Charlotte Storm Water
600 East Fourth Street
Charlotte, N C 28202-2844

Rezoning Petition Review

Date of Review: March 23, 2020 (***Revised April 16, 2020***)

Rezoning Petition #: 20-35

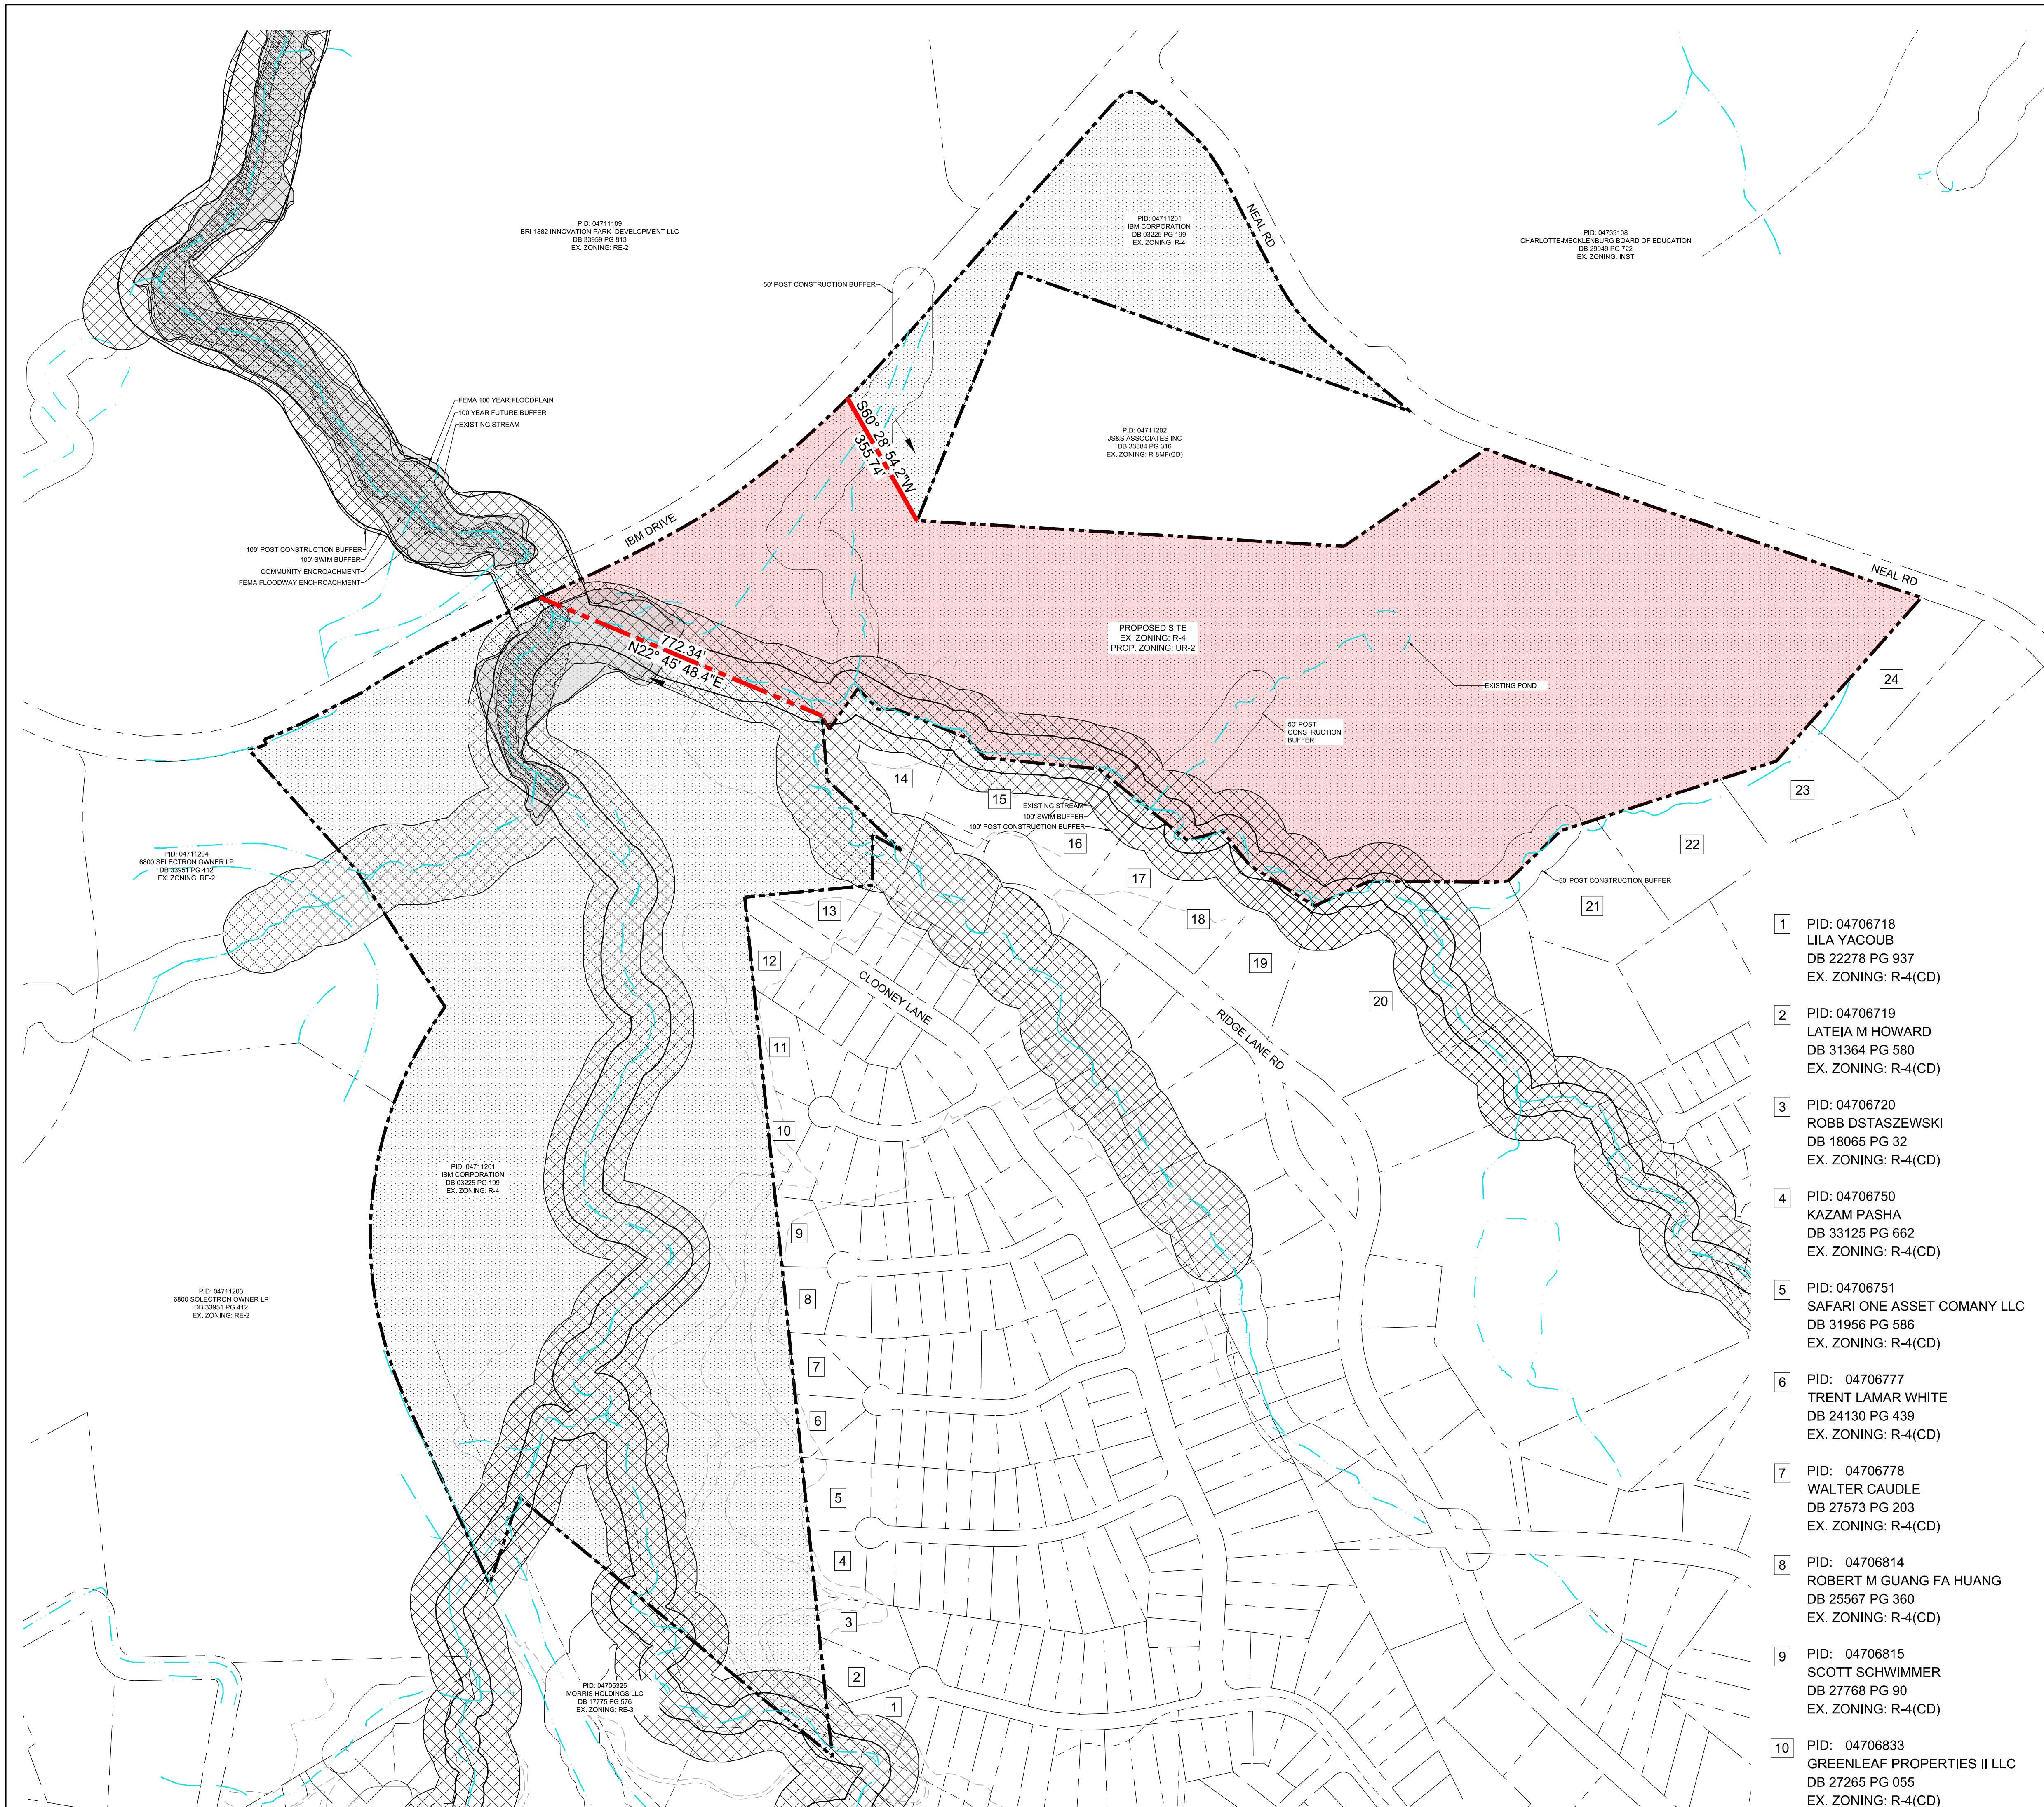
Concerning Storm Water: Please include the following sentence to the end of note 1 under *Environmental Features*: *Adjustments may be necessary in order to accommodate actual storm water treatment requirements and natural site discharge points.*

Please update 50' Post Construction Buffer and 100' Post Construction Buffer to read 50' Undisturbed Post Construction Buffer and 100' Undisturbed Post Construction Buffer. Development within any SWIM/PCSO Buffer shall be coordinated with and subject to approval by Charlotte-Mecklenburg Storm Water Services and mitigated if required by City ordinance.
